**PUD DEVELOPMENT PLAN - SITE DEVELOPMENT PLAN**  
**ROLLIN RIDGE OFFICE / COMMERCIAL CENTER**  
 EL PASO COUNTY, COLORADO  
**TC & C, LLC**  
 17572 COLONIAL PARK DRIVE MONUMENT, CO 80132-2209

sheet number: **2** OF SIX  
 PUD PROJECT NO: P18-001

PUD-18-003

**SITE DEVELOPMENT PLAN
PUD DEVELOPMENT PLANS
ROLLIN RIDGE ESTATES COMMERCIAL CENTER**

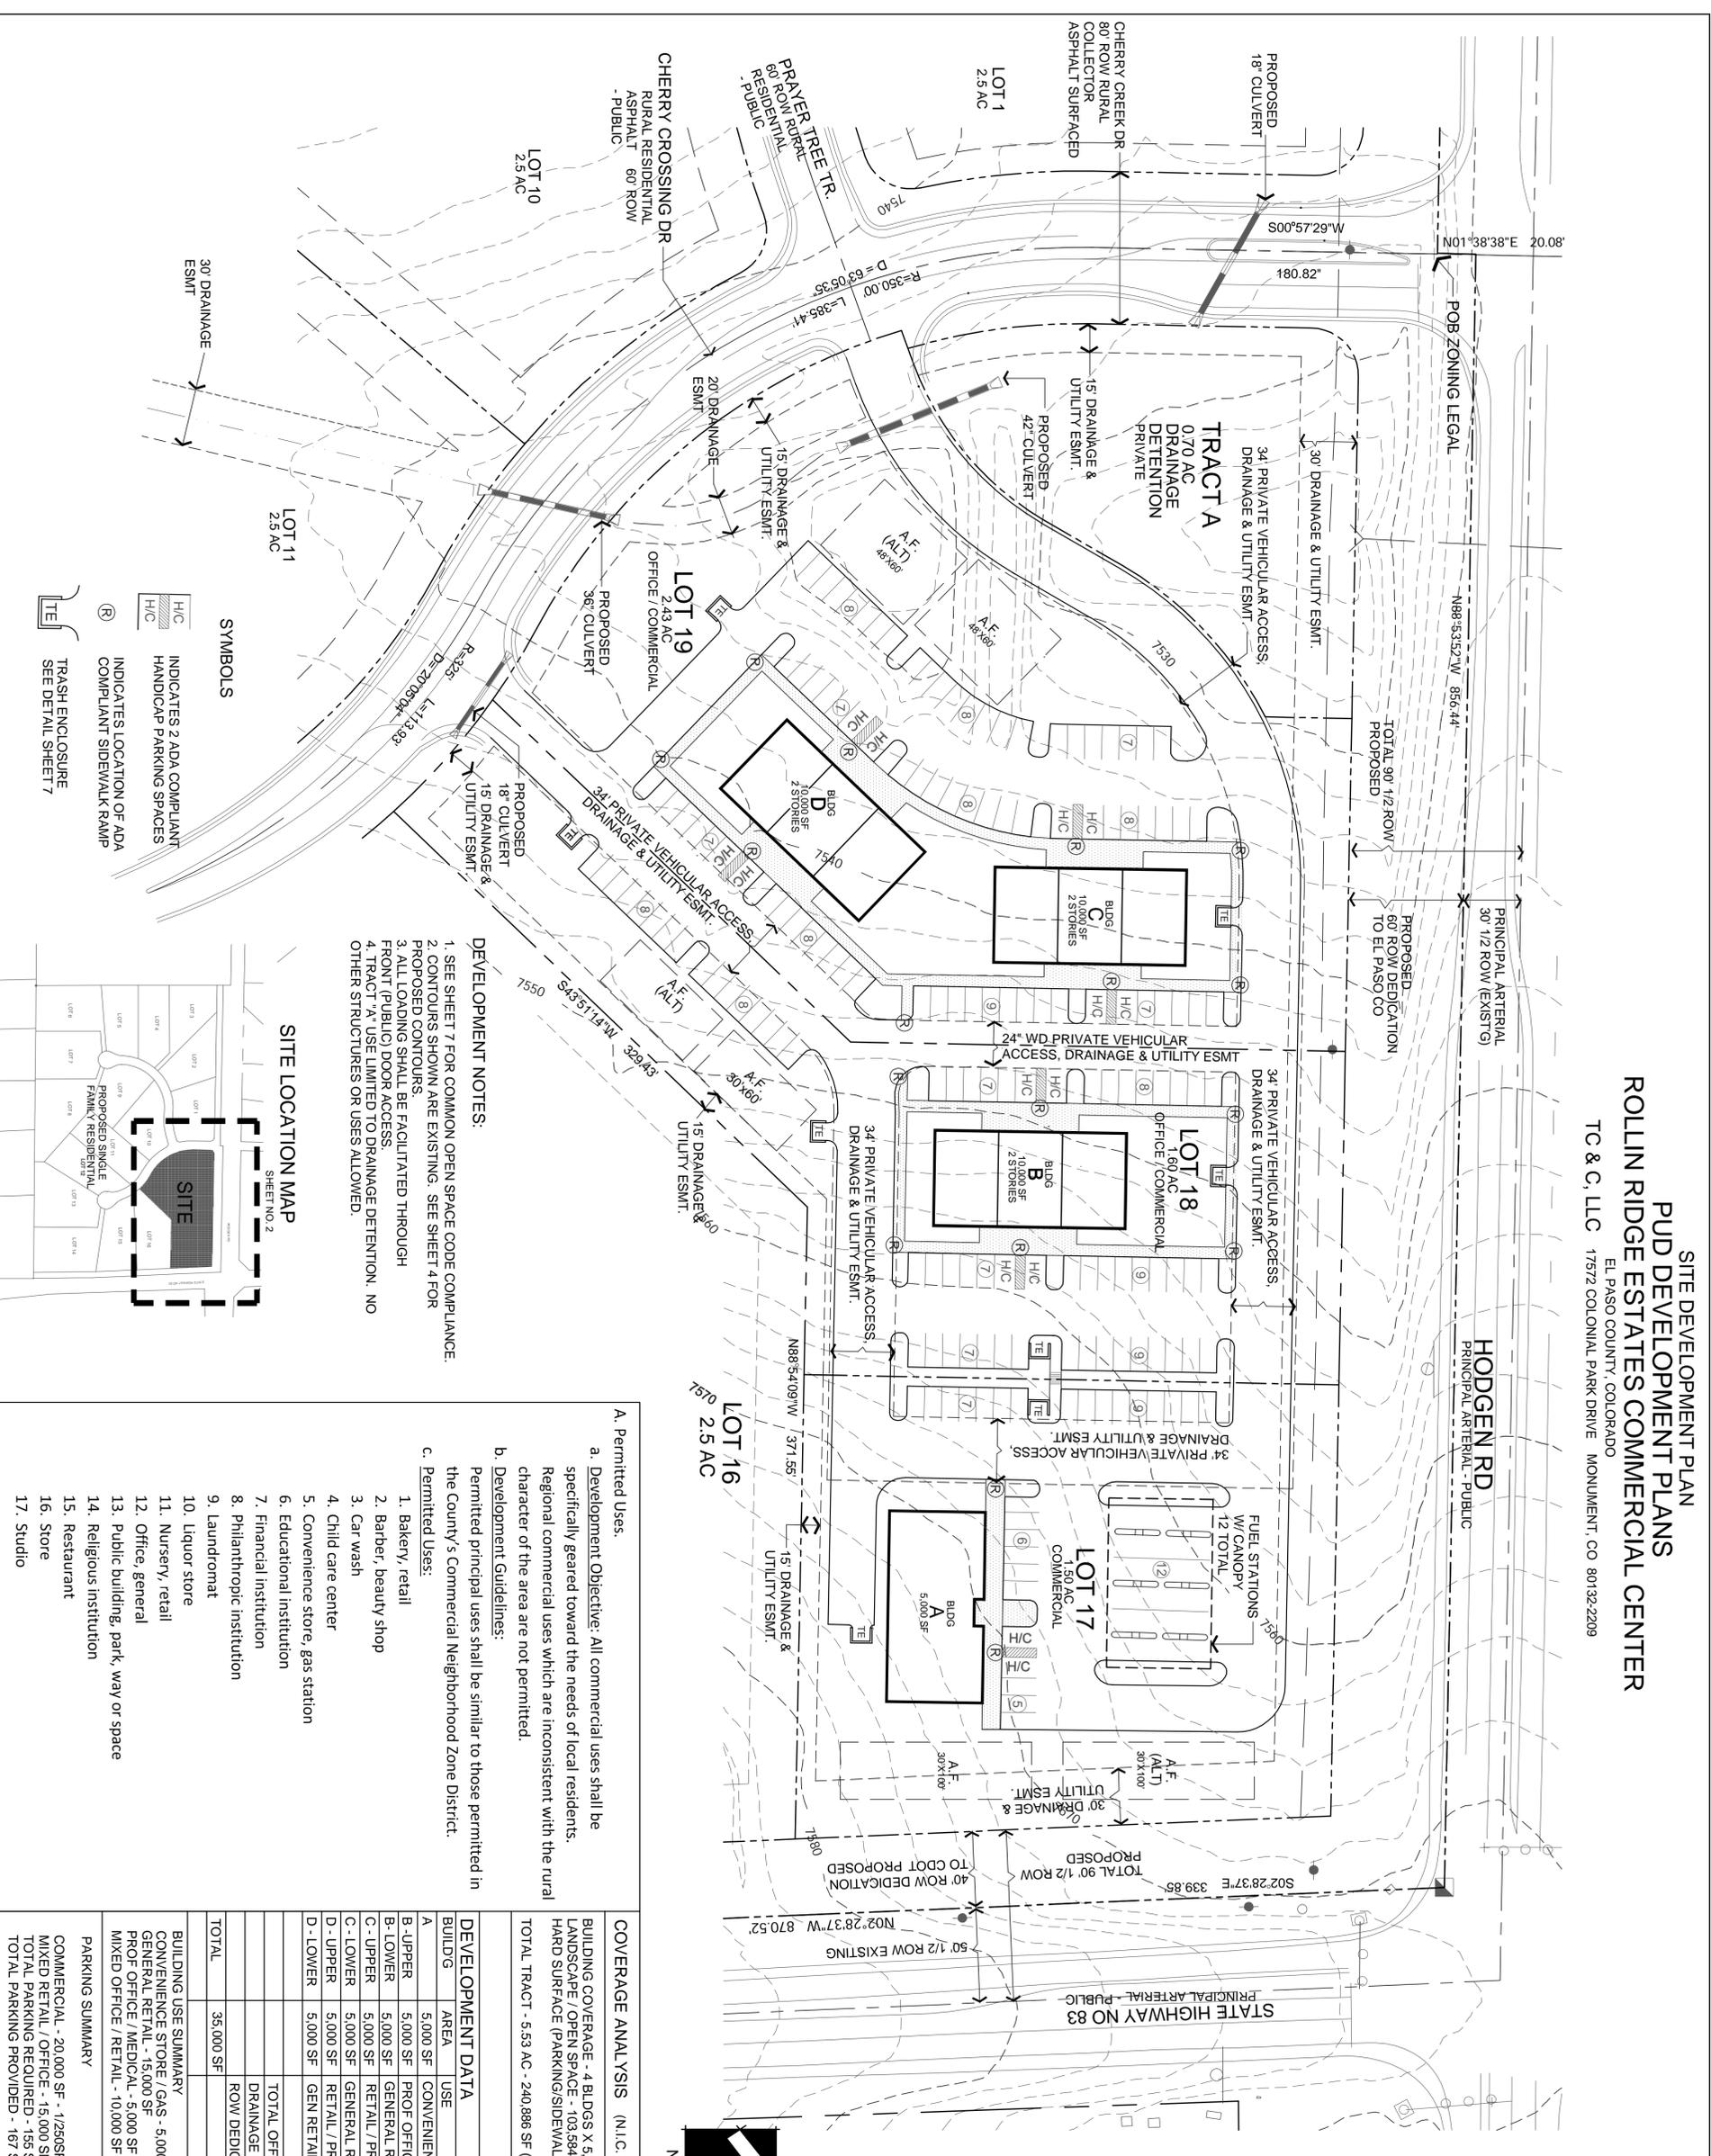
Original comment requested to show the kink in the ROW that the EPC assessors office shows. Please confirm if this kink is correct and show it on this plan. additional comments may be generated when this kink is shown.

The allowed uses provided on the Development Guidelines can be added here for a cleaner PUD Development Plan;  
Previous redline note not address for a more refined use table

Section 4.2.6(8) Common Open Space Requirements are not mentioned or depicted on PUD Development Plan.

SUBDIVISION & BLDG SETBACK PLAN
 PUD DEVELOPMENT PLANS
ROLLIN RIDGE ESTATES COMMERCIAL CENTER
 TC & C, LLC 17572 COLONIAL PARK DRIVE MONUMENT, CO 80132-2209

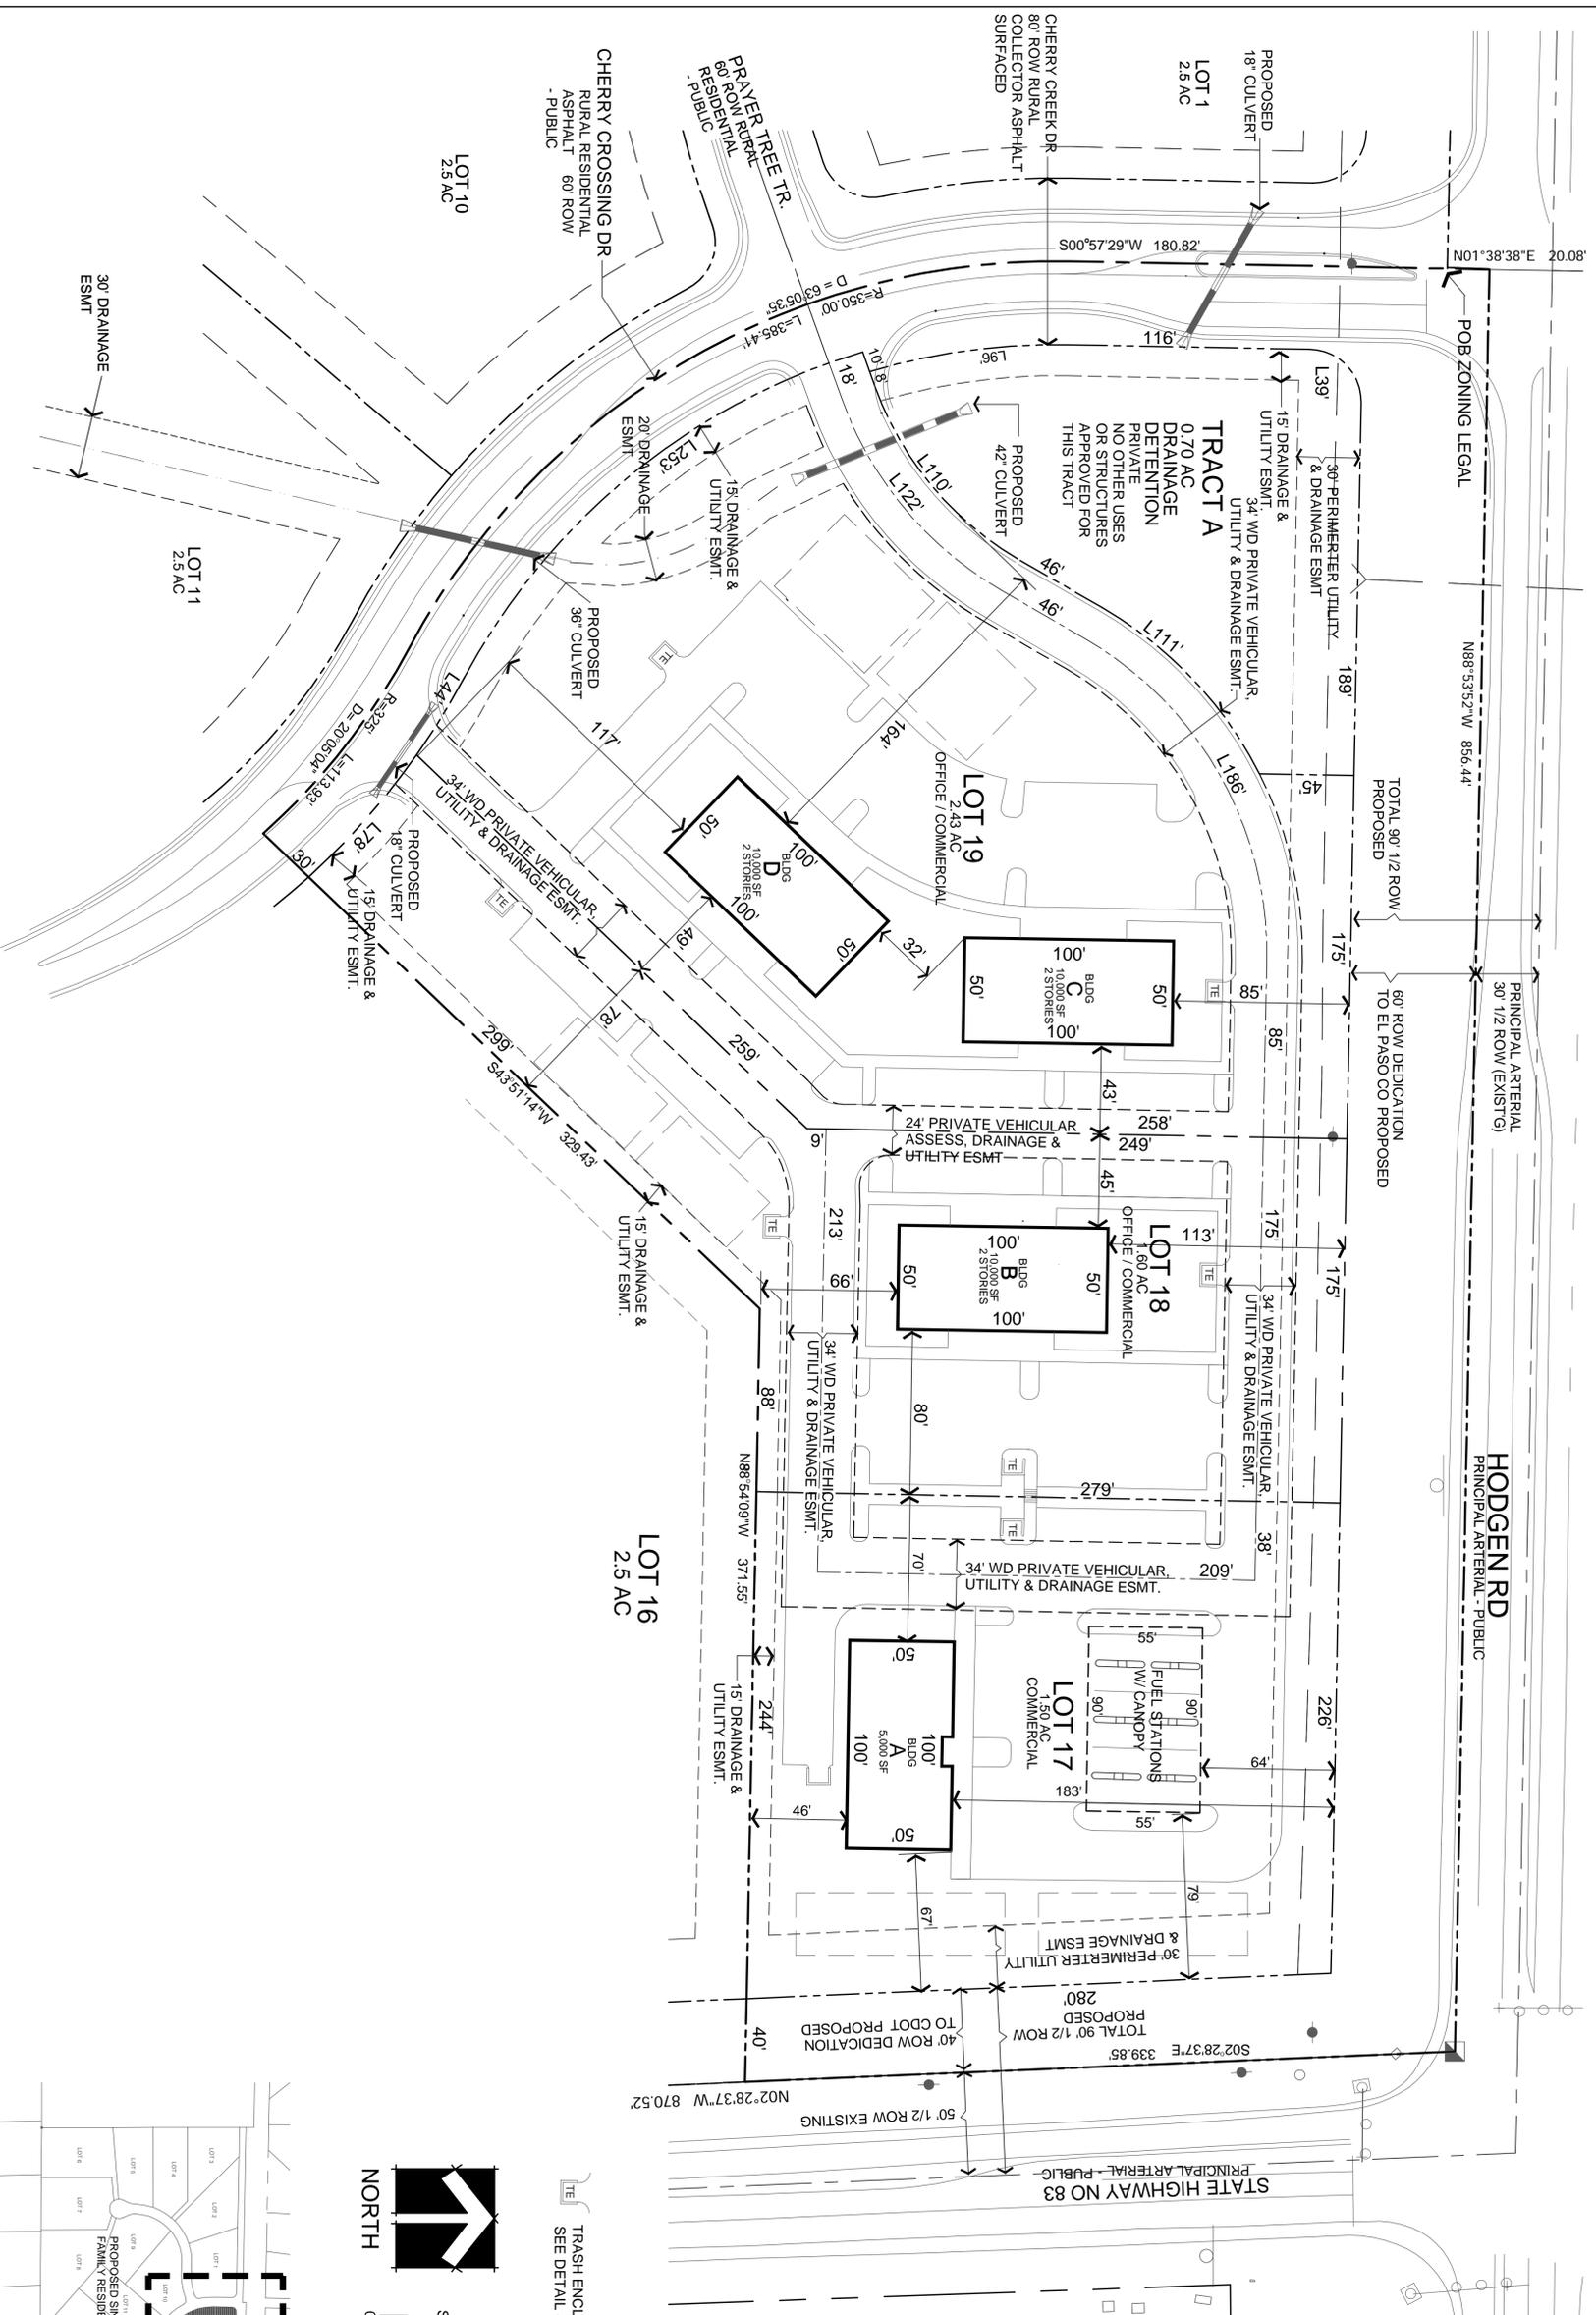
is this drainage and utility?

another call out to the development guidelines but setbacks direct back to PUD Development Plan, suggested to combine the guidelines into the Development plan or information from both documents need to be identical

Previous Redlines for Tract A to identify any other uses and/or structures that may be placed in this tract not addressed.

LANDSCAPE & SIGN FEATURES PLAN
 PUD DEVELOPMENT PLANS
 ROLLIN RIDGE ESTATES COMMERCIAL CENTER
 EL PASO COUNTY, COLORADO
 TC & C, LLC 17572 COLONIAL PARK DRIVE MONUMENT, CO 80132-2209

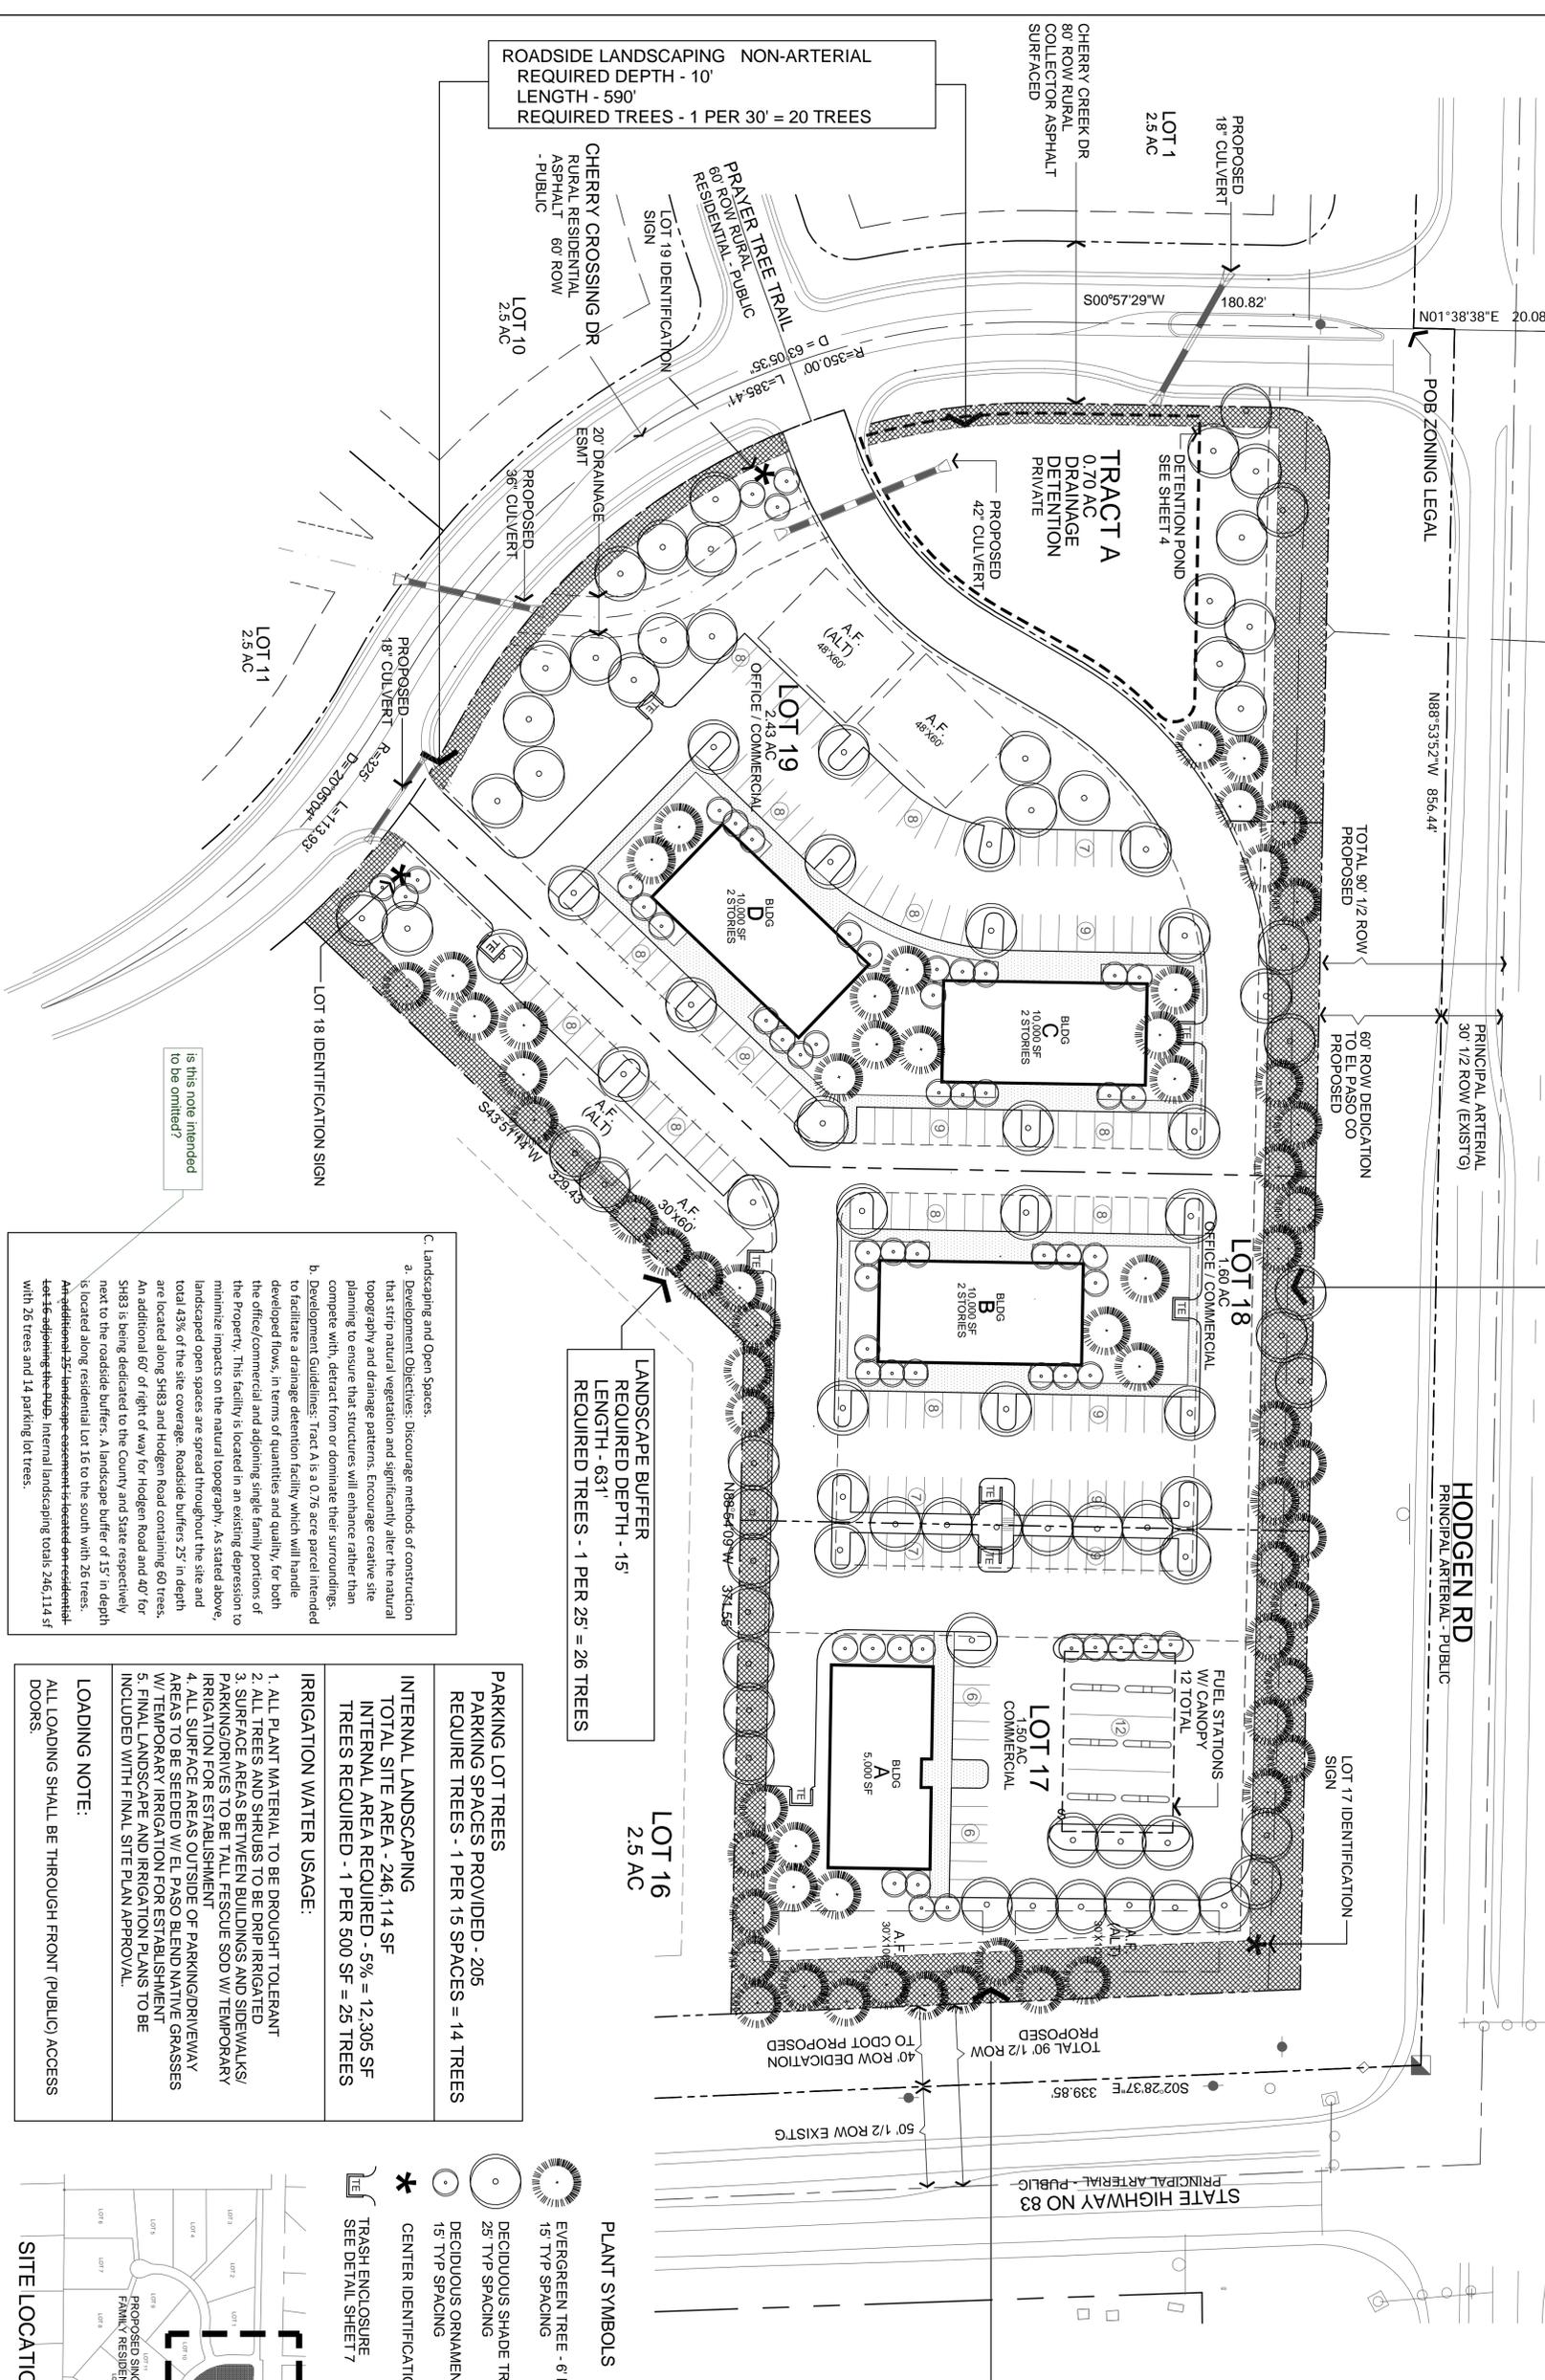
Elevations required for trash enclosure

There is not a depiction for Lot 18 sign location
